**From:** Anita Gardner  
**Sent:** 10 July 2018 11:44  
**To:** Planning.Responses  
**Subject:** FW: LU/67/18/PL - Outside seating,14-18 Surrey Street, Littlehampton  
**Importance:** High

**From:** Anna Appleton  
**Sent:** 10 July 2018 11:37  
**To:** Anita Gardner  
**Cc:** Planning.Responses  
**Subject:** FW: LU/67/18/PL - Outside seating,14-18 Surrey Street, Littlehampton  
**Importance:** High

EH and Licensing note the points made within the residual risk rating document submitted with the application but we still have concerns about this application due to the following issues:

CLIENT	JD WETHERSPOON PLC		
PROJECT	PUB NO: 534 THE GEORGE INN LITTLEHAMPTON		
DRAWING	PROPOSED PAVEMENT CAFE		
SCALE	A3/1:50	DATE	MAR 2018
PROJECT No	7508	DRAWING No	03
		DRAWN	ALS
		REVISION

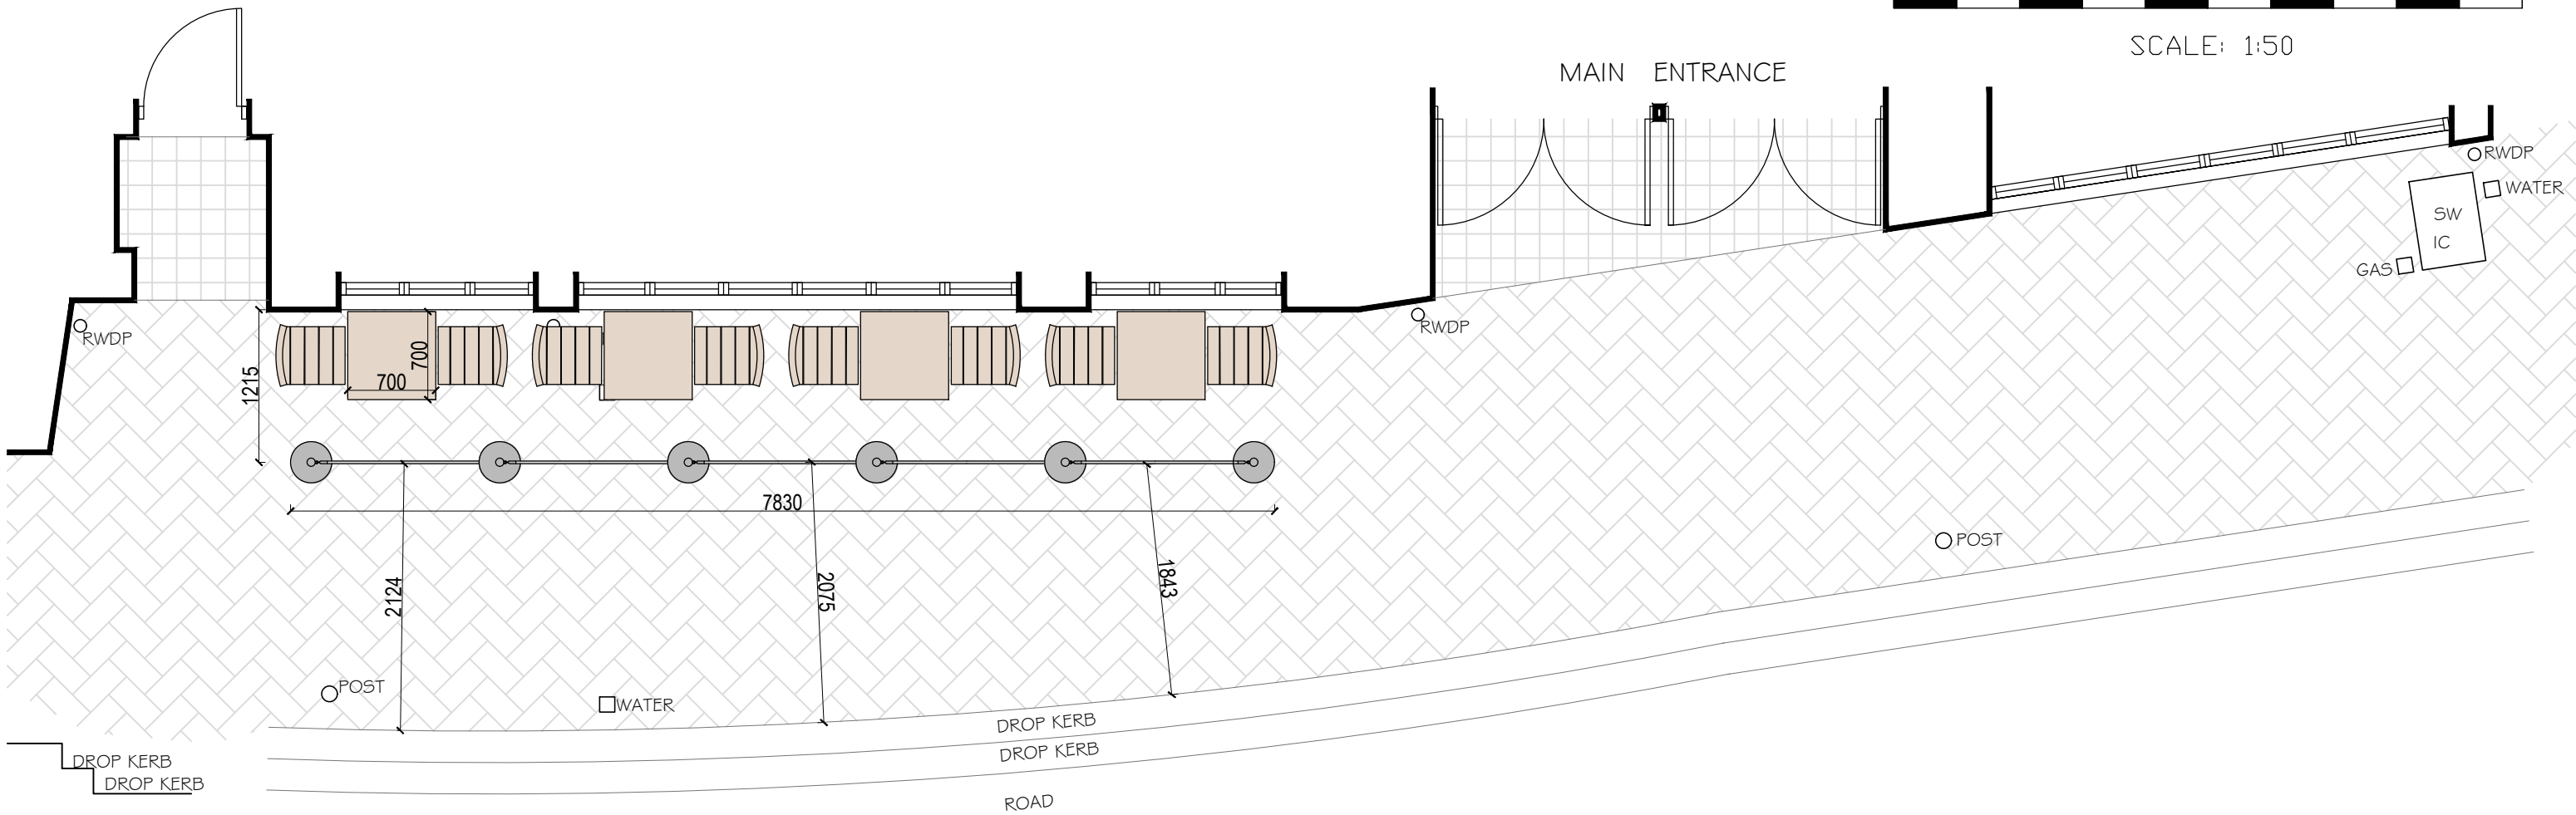
4. The addition of seats in this area could inhibit access along the pavement as the area is already commonly used to park mobility scooters and there are also bikes attached to the lamp post opposite the door.
